**KIRKLEES METROPOLITAN COUNCIL
INVESTMENT & REGENERATION SERVICE**

Reference No: 2021/62/91662/W

Site Address: 50, Market Street, Milnsbridge, Huddersfield, HD3
4HT

Description: Change of use and alterations to derelict chip shop to
form one dwelling and refurbishment of existing first
floor flat (within a Conservation Area)

Front Elevation (West Facing)
1 : 100

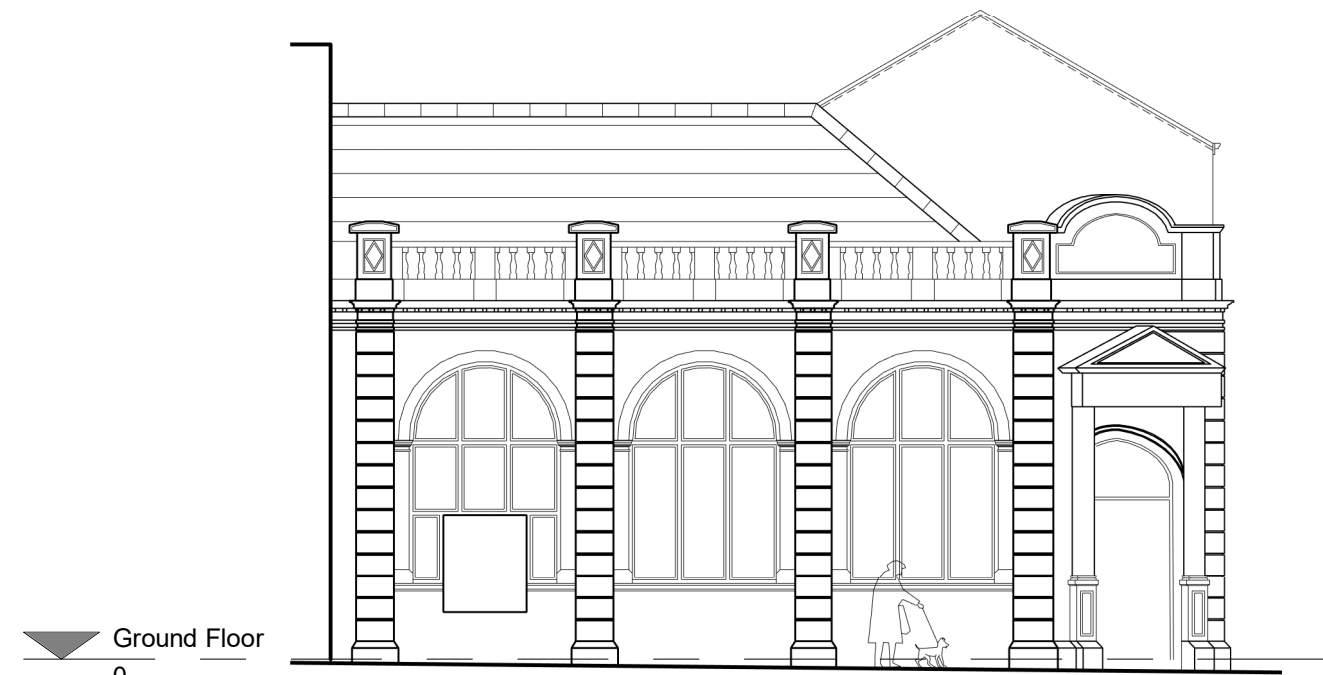
2 – Impact on visual amenity: According to the design & access / heritage statement, the building is structurally sound and only in need of superficial repair and refurbishment. Replacement windows and doors are proposed but no new openings. The existing and proposed elevations indicate that the replacement ones would be similar in appearance.

The application form says that windows are to be replaced with UPVC and door with composite. As the building is of traditional appearance and the existing windows contribute positively to its character, the use of UPVC frames should be avoided. The architect has accepted that in principle painted timber can be used but would prefer not to have to install sash windows, which it appears the existing ones are. It may be possible to allow some flexibility on window design other than like-for-like replacement, but this can be the subject of a condition requiring details to be submitted.

3. Notwithstanding the details on the application form, the use of UPVC windows is not approved for the front elevation of the building. All new windows in the front elevation shall be timber. Design details of windows and of the new front door at a scale of 1:50 or larger shall be submitted to and approved in writing by the Local Planning Authority before any replacement of the existing windows or doors commences and the development shall be implemented in accordance with the approved details. All new windows shall be given a painted finish externally before either flat is first occupied.

Ground Floor
1 : 75

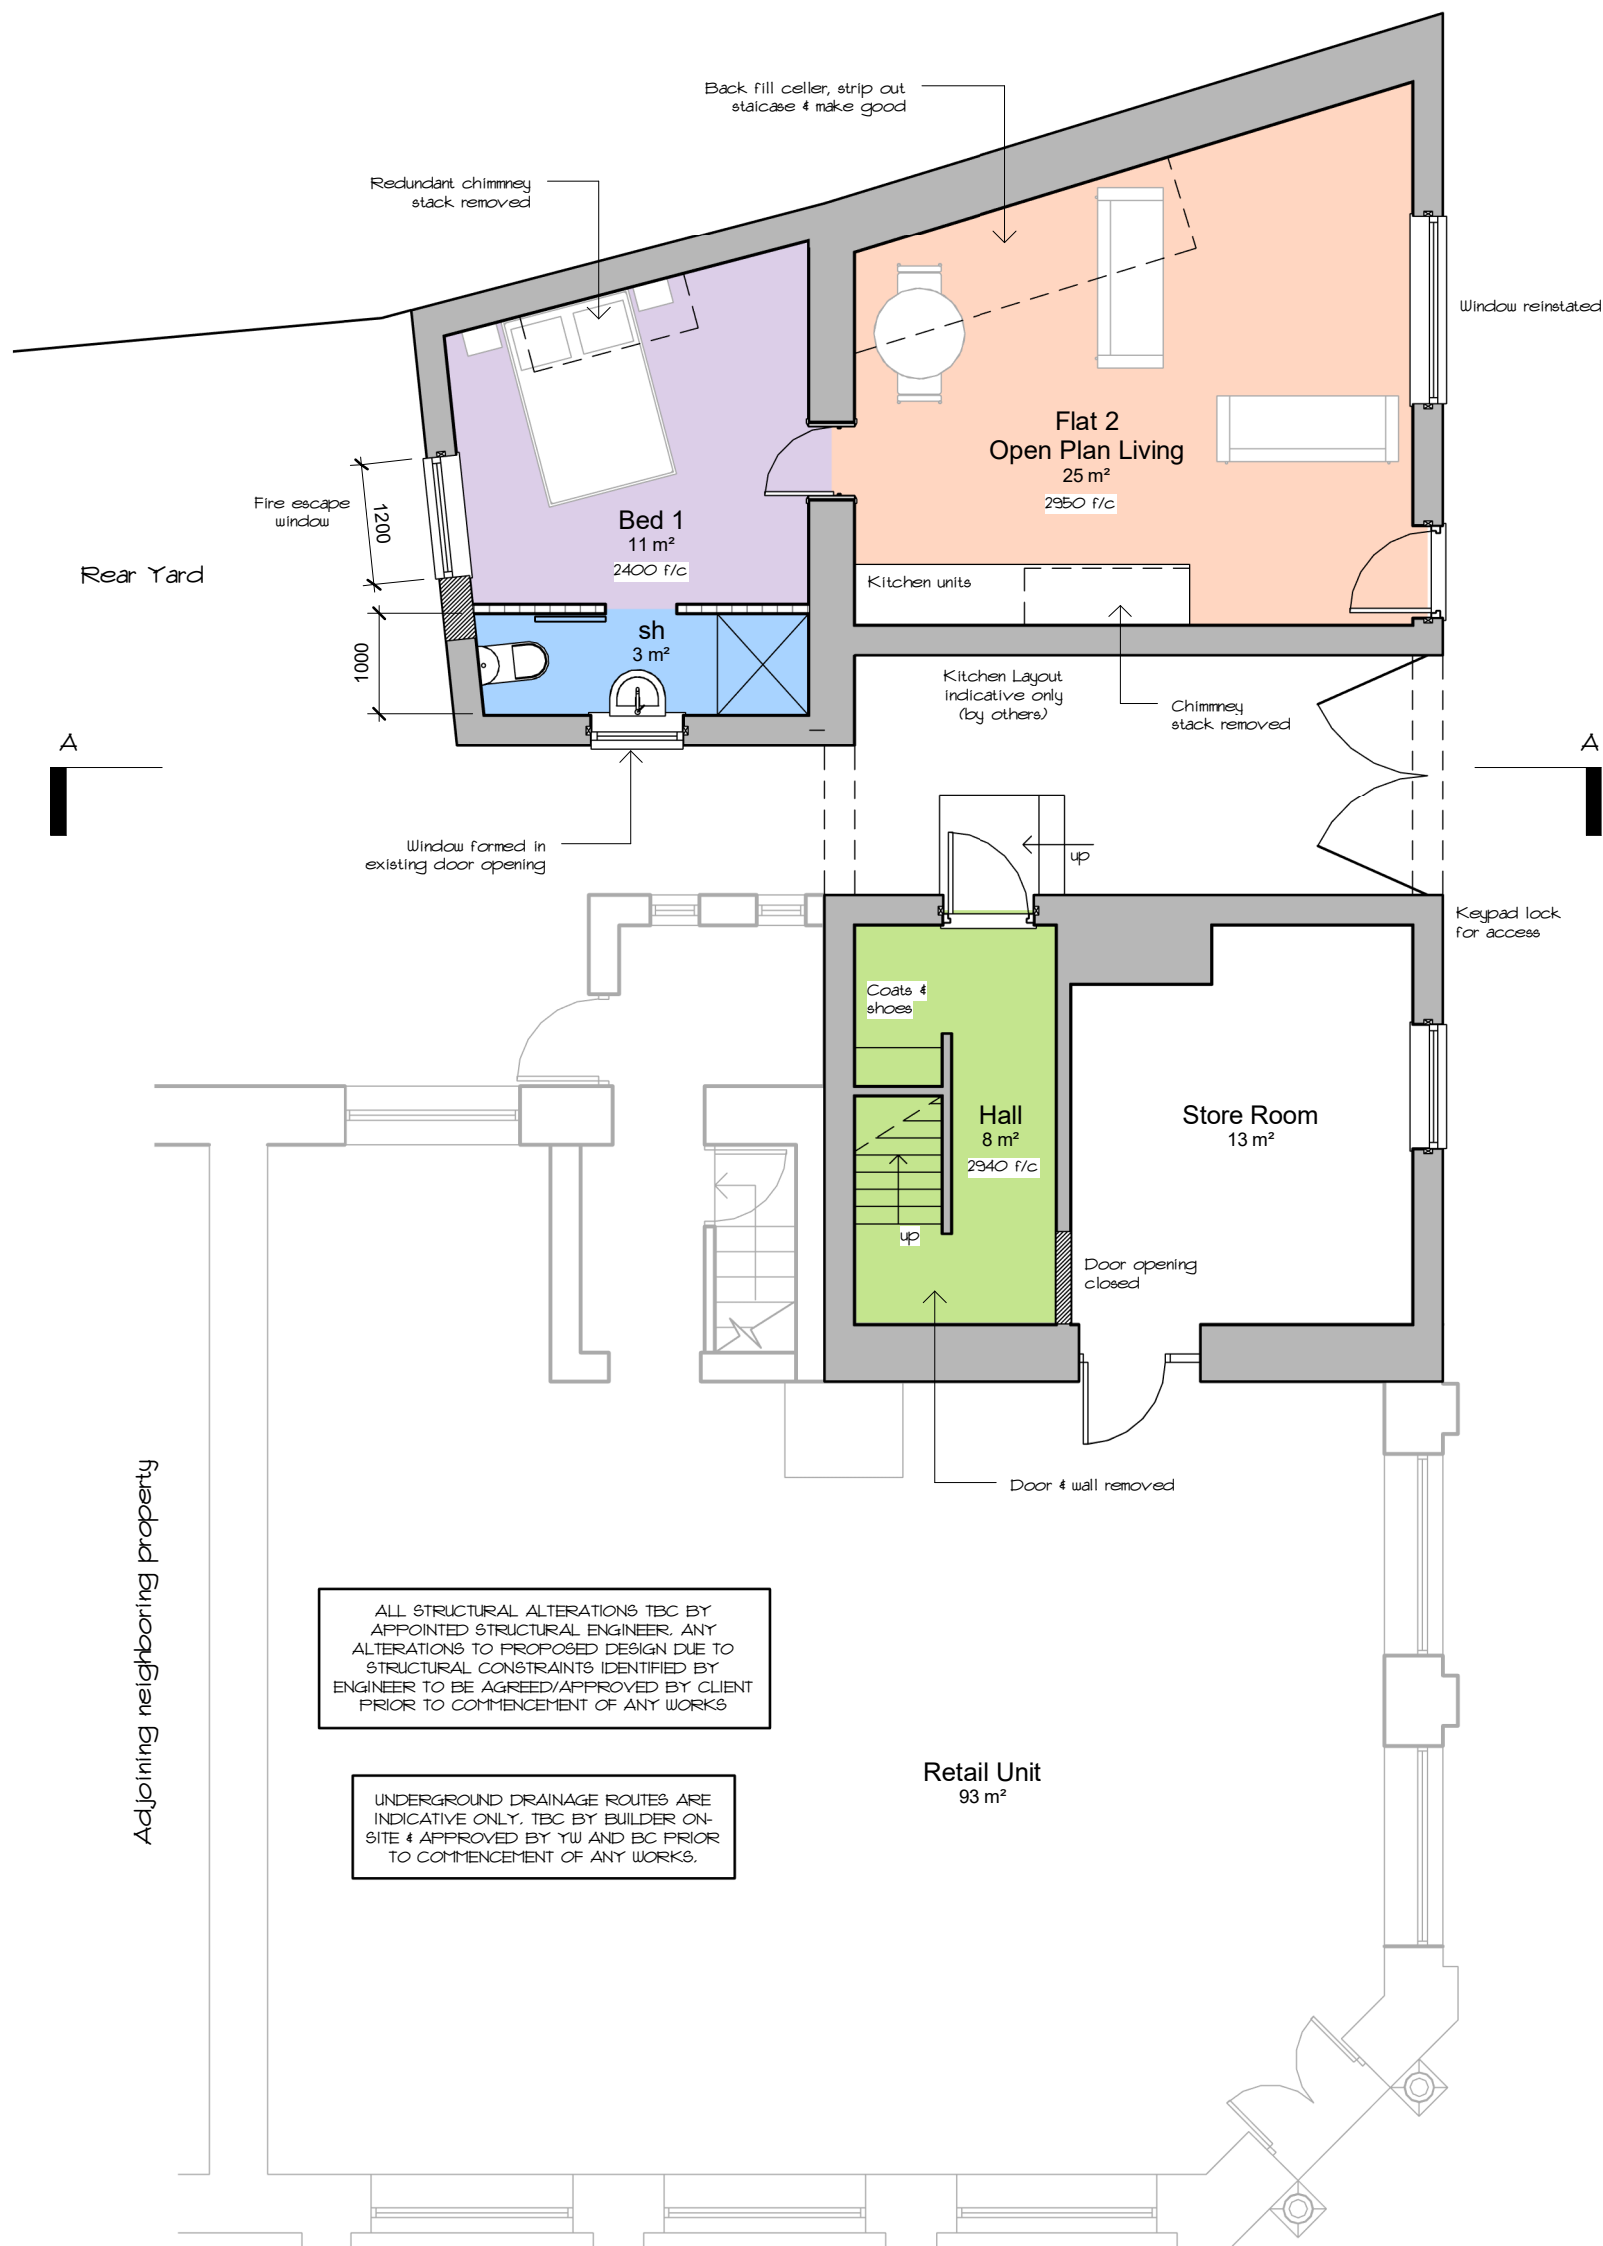
The ground floor flat would comprise a single bedroom and an open-plan living area, total floor area 40sqm. The bedroom would have a main window facing north and a secondary window formed in the existing west-facing doorway. The store that lies immediately to the north of the building and abuts it is to be demolished.

The bedroom window in the ground floor flat would face the nearest opposing wall at a distance of 6m and would be roughly 4.5m from the land boundary with the adjacent property. However, it would be immediately facing a single-storey not a two-storey structure, and the secondary window, as shown on the latest amended plans, would provide extra light. Outlook would be generally limited as it would face on to an enclosed courtyard, but this would be somewhat compensated for by the more open aspect for the living room to the front.

Project No. 2021 Enquiry 76
Project Title proposed first floor plan
option 1 single bed (little disruption)

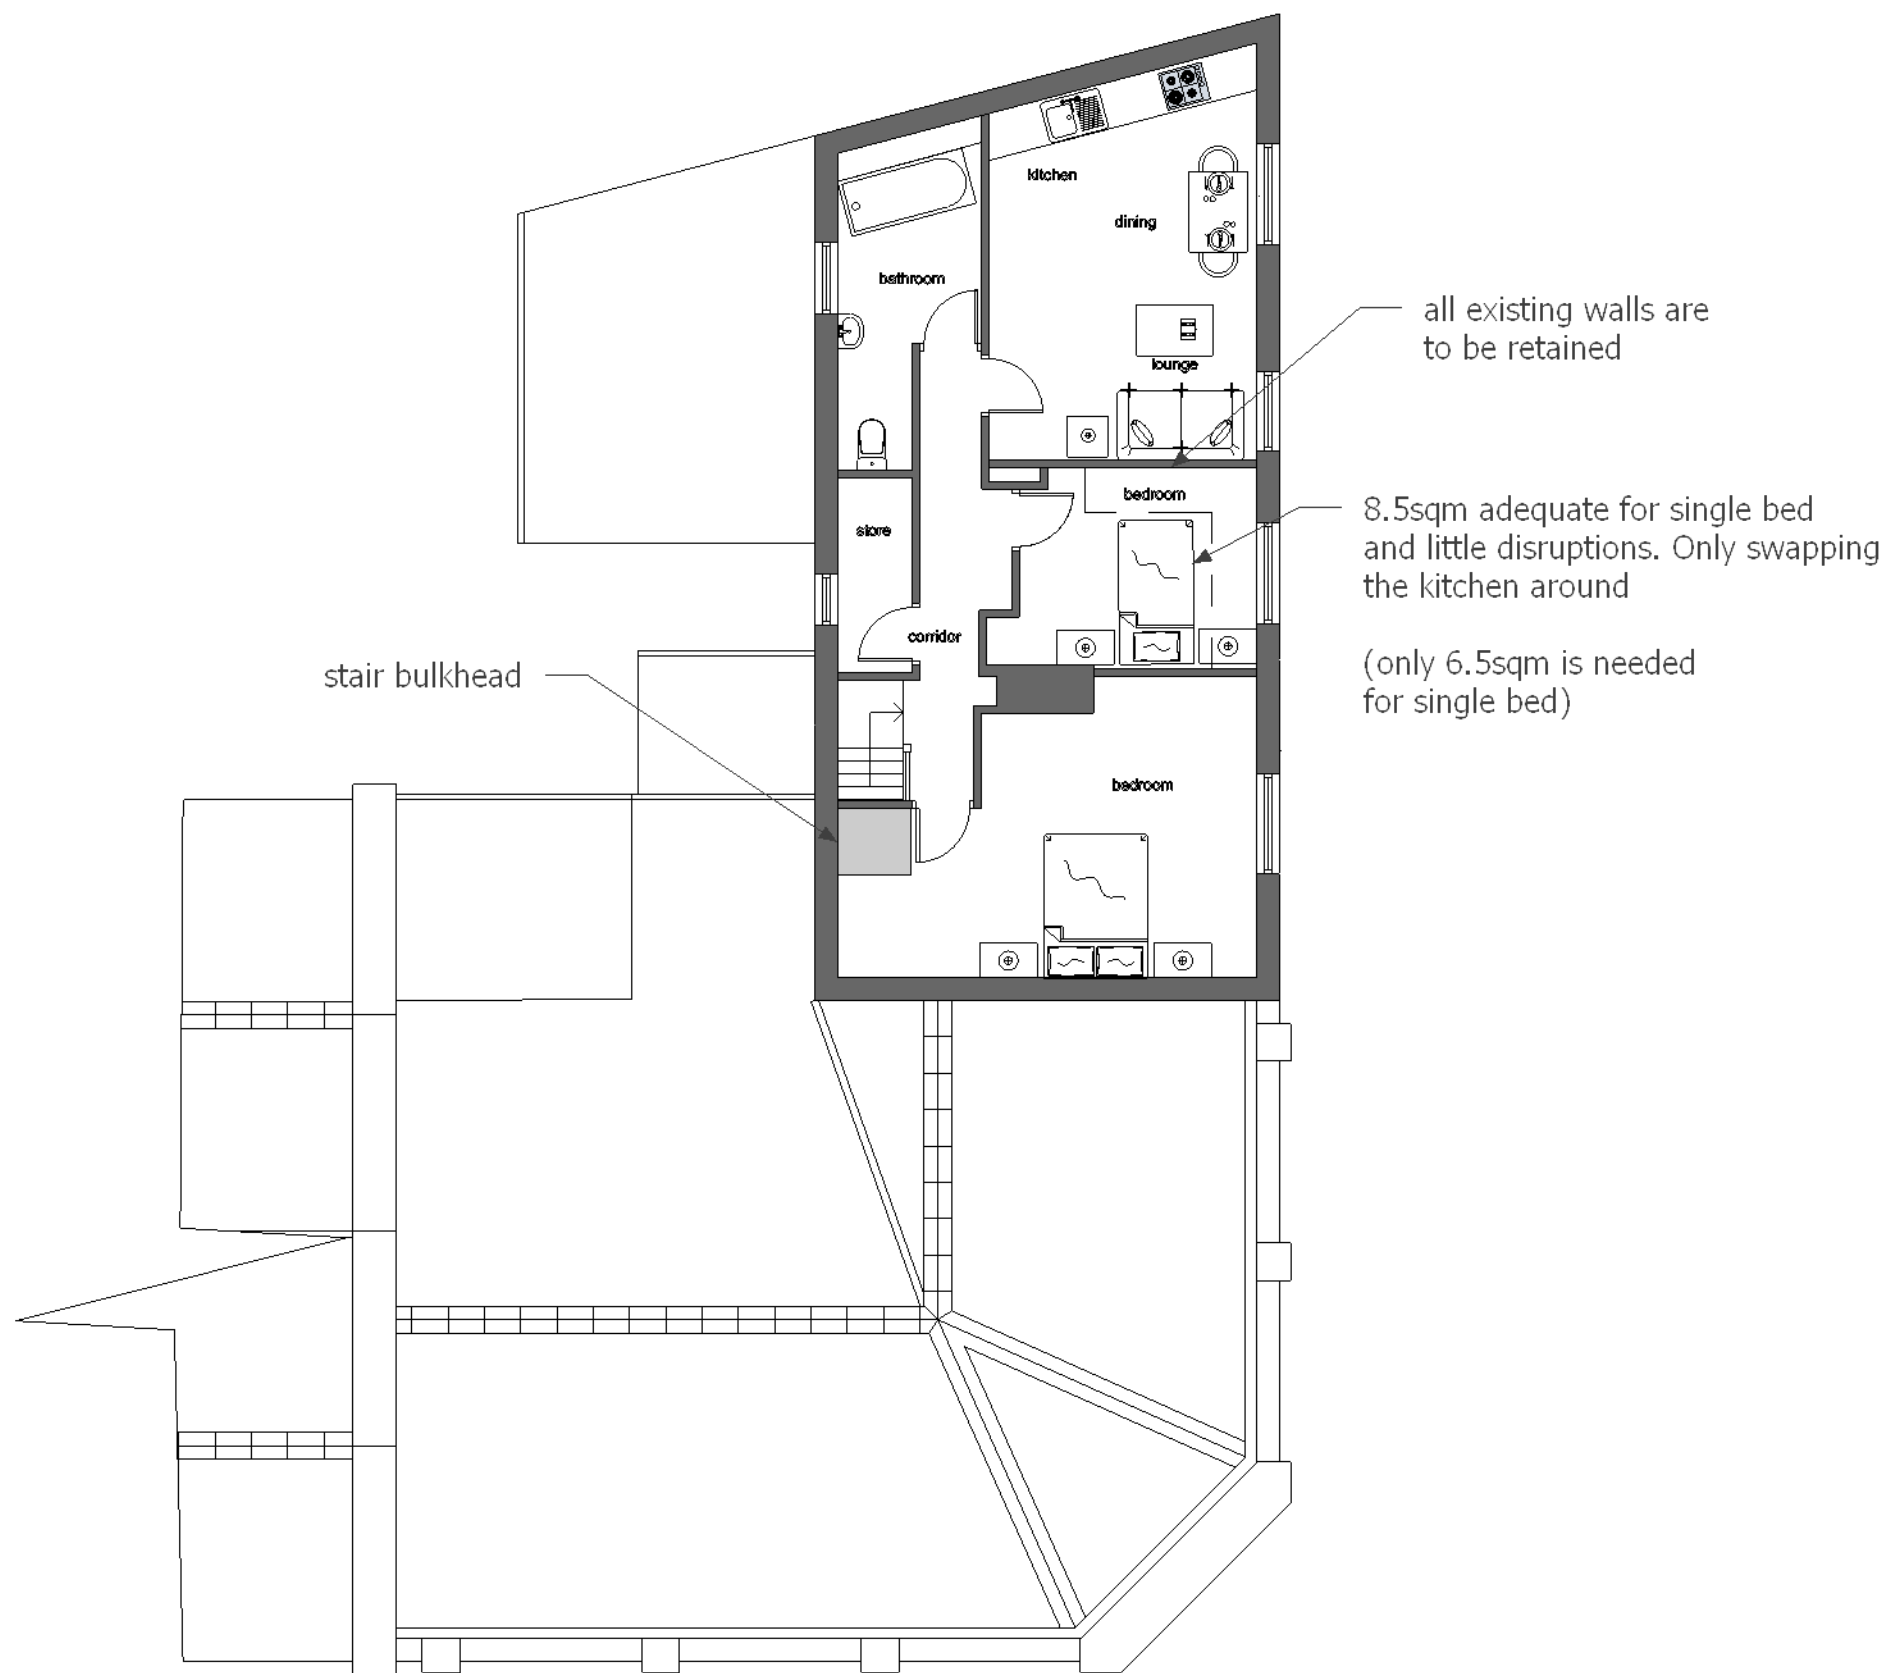
The first-floor flat would have a total internal area of about 64sqm and would have 2 bedrooms. All the principal windows, except for the bathroom, would face George Street.

Part 7.3 of the Housebuilders' Design Guide SPD sets out recommended separation distances for two-storey dwellings. The same principles can be applied at least in the case of the upper floor flat. The separation distance between its own south-facing windows and 45-47 George Street would be about 11m. The SPD recommends maintaining 21m between habitable room windows where these are at the rear of the site and the figure may be considered as a starting point for windows facing each other at the front.
